FW: P/5/26/PL

'1 No 4-bed chalet bungalow, alteration of existing bungalow to include off-street parking and rear dormer extension (resubmission following P/118/25/PL). This application is in CIL Zone 4 and is CIL Liable as a new dwelling.'

Proposed Roof Plan 44

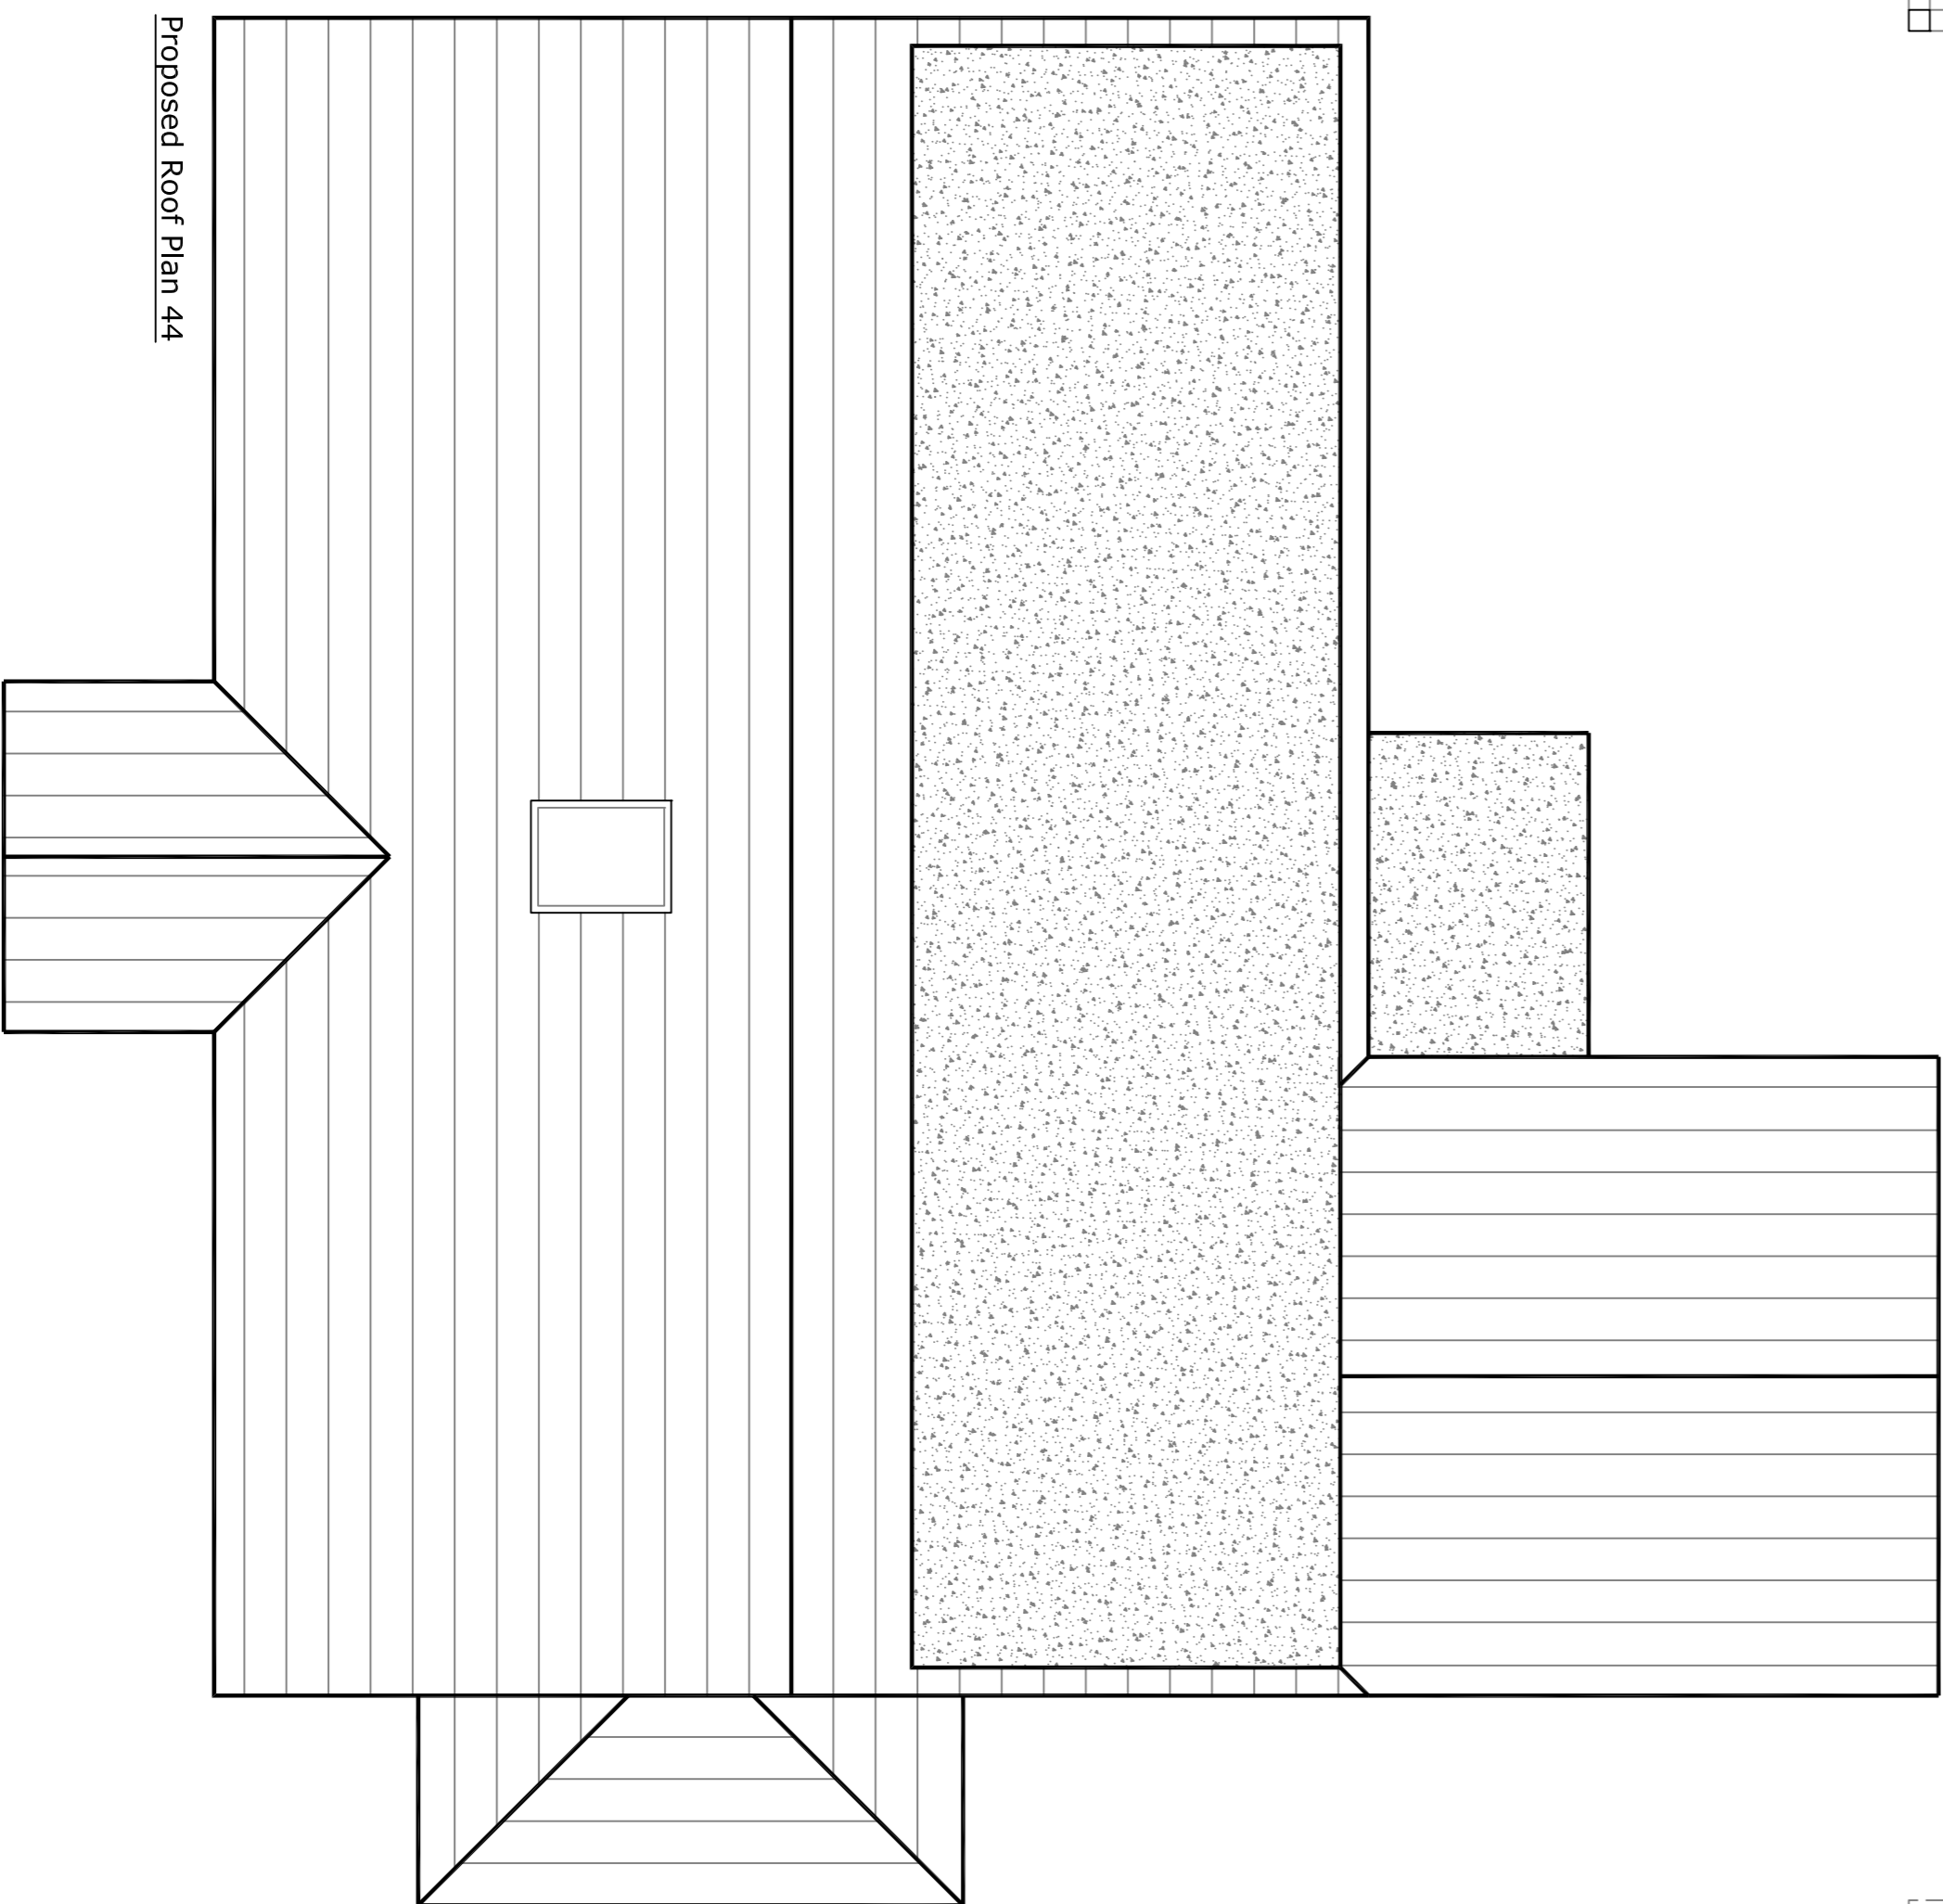
Following review, could I request that the rear dormers of both dwellings are reduced in width, perhaps at least by 0.5m each side, and that they are set back into the roof slope slightly further by perhaps a couple of rows of tiles. Our aim is to reduce their dominance of the rear roof slopes.

Thanks for your email, please see attached amended plans, I think I have covered everything you needed but if I have missed something please let me know and I will change. Am I correct in thinking that this application is now looking more favourable than the last? Thanks

Proposed First Floor Plan 44A

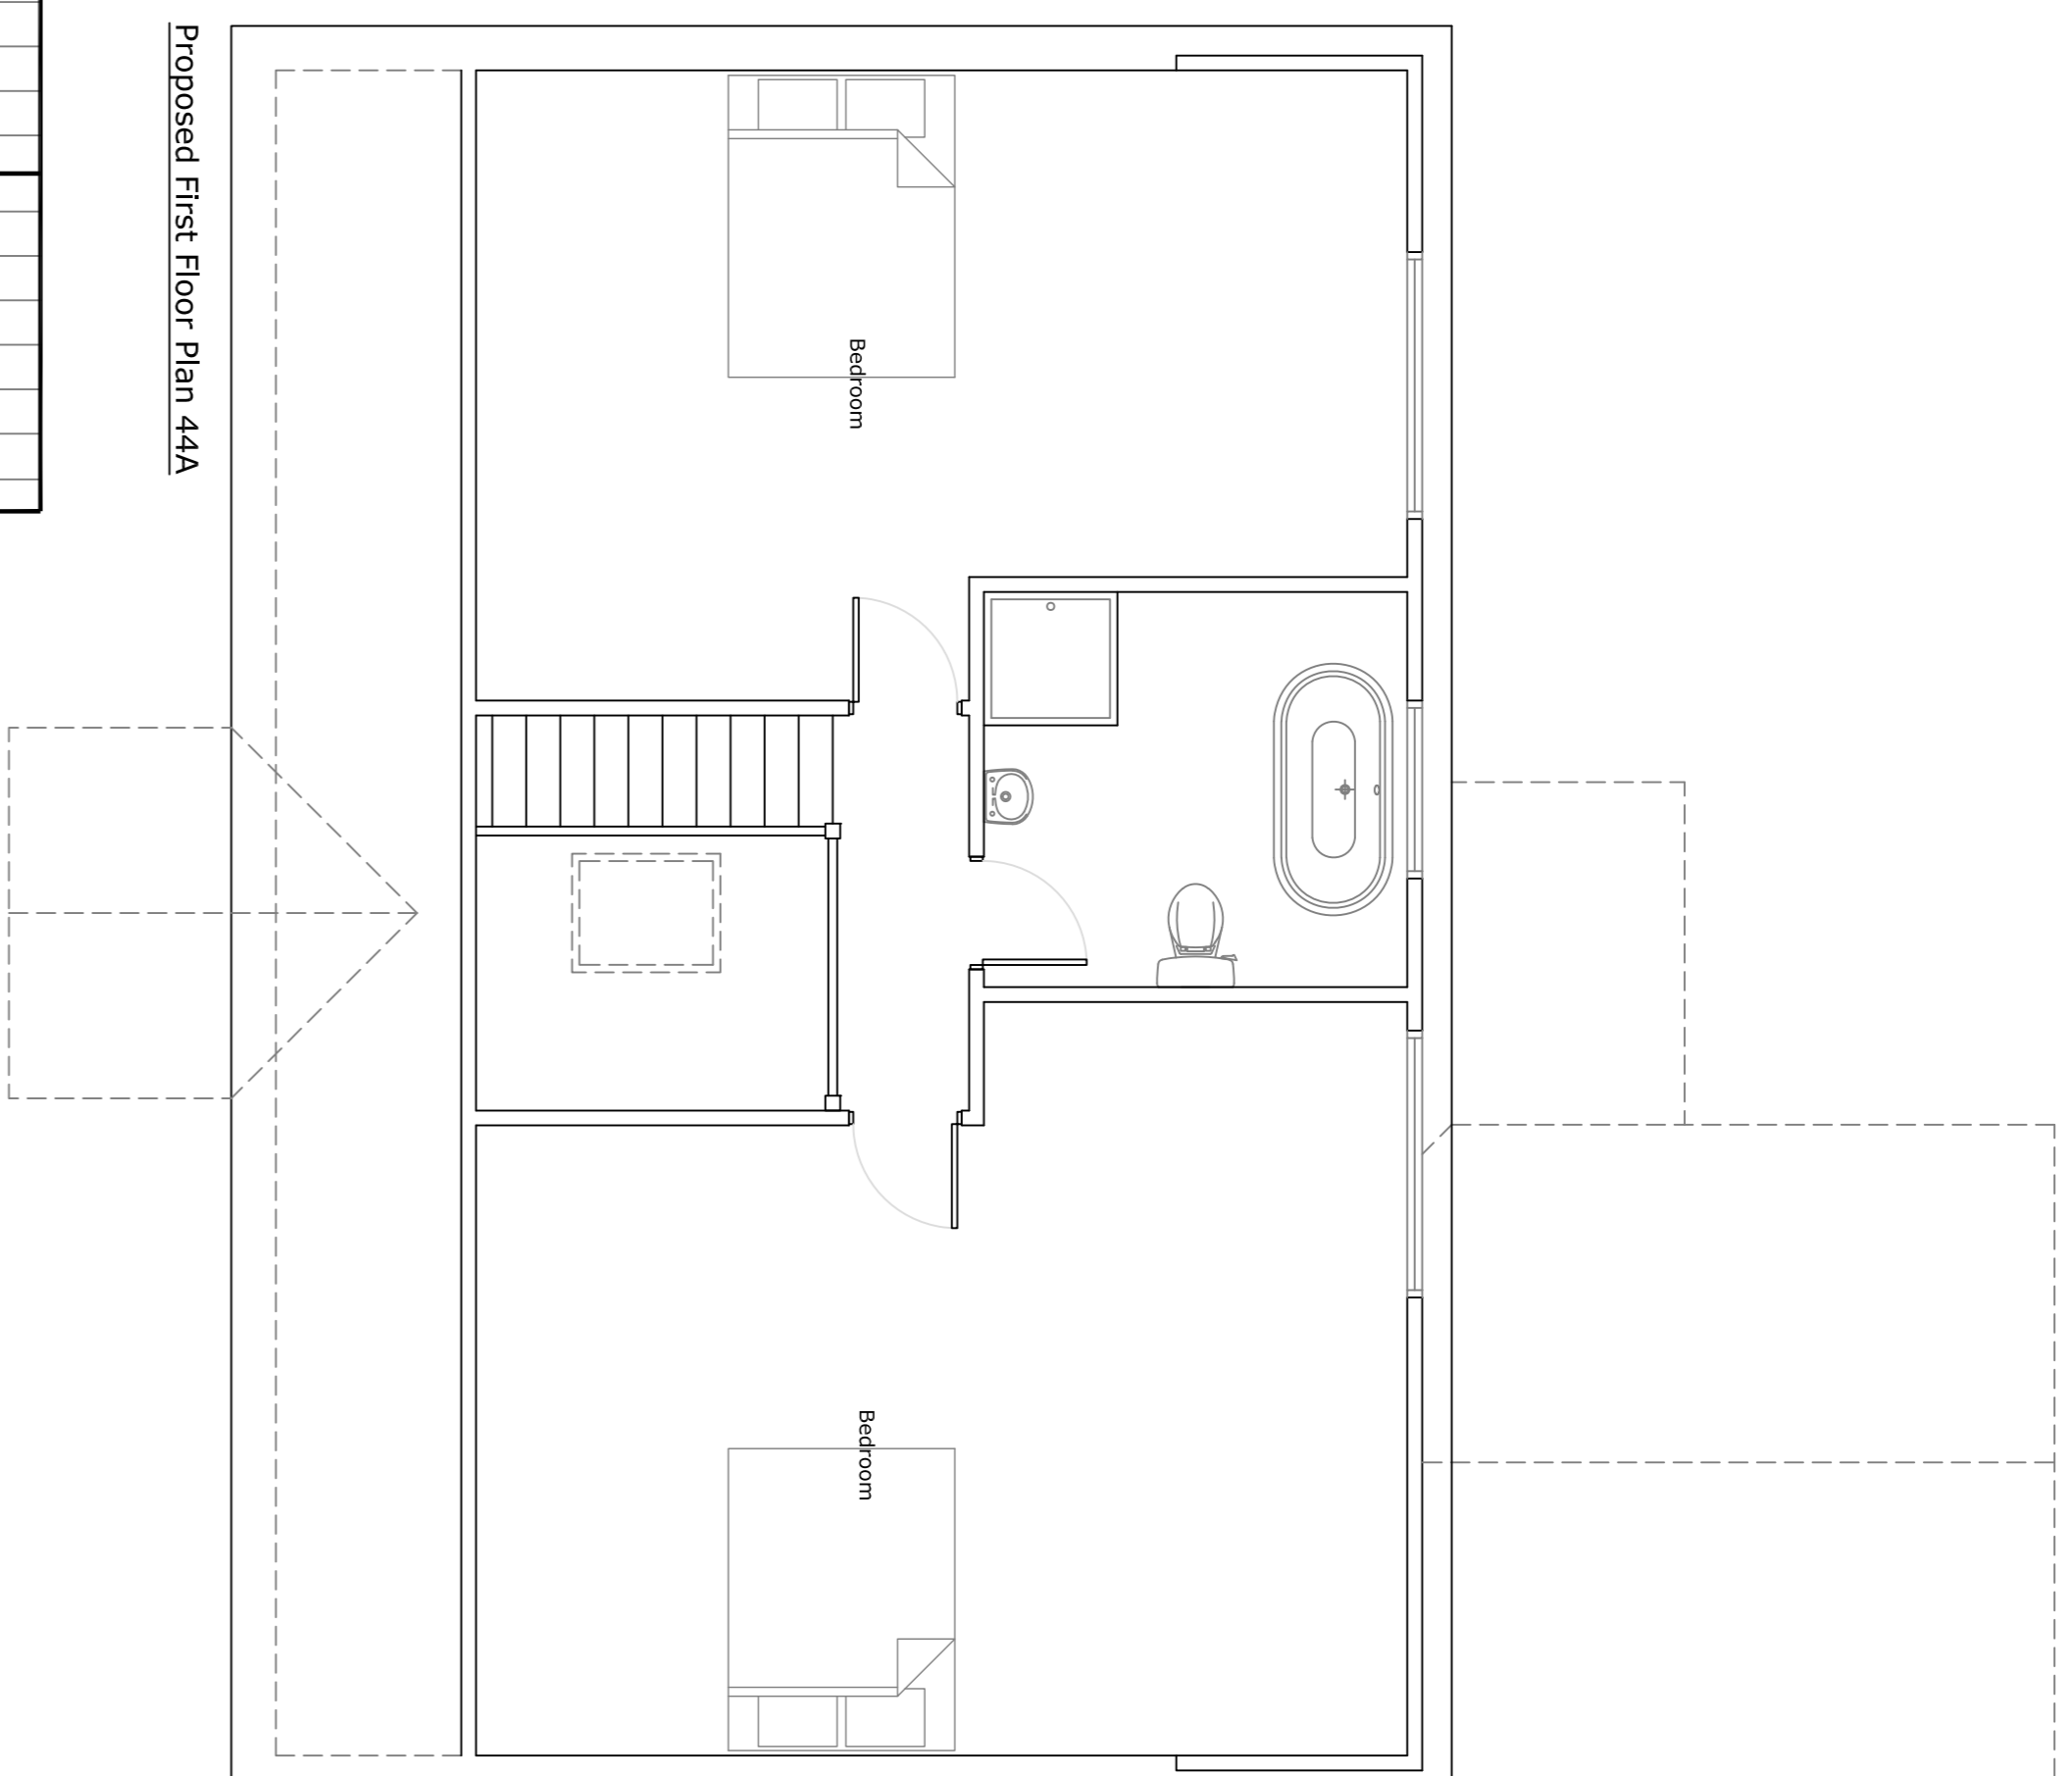
Could I also request that the northernmost first-floor rear window within the dormer of No. 44A be reduced to a two-pane casement? With the new design and relocation of the single-storey component, there is a greater perceived and actual overlooking impact of No. 2 Sea Way. The aim of this is to reduce how imposing this viewpoint may feel within the eastern end of No.2's plot, acknowledging that the eastern end of that plot is not the primary amenity space, but still remains of amenity value to the property.
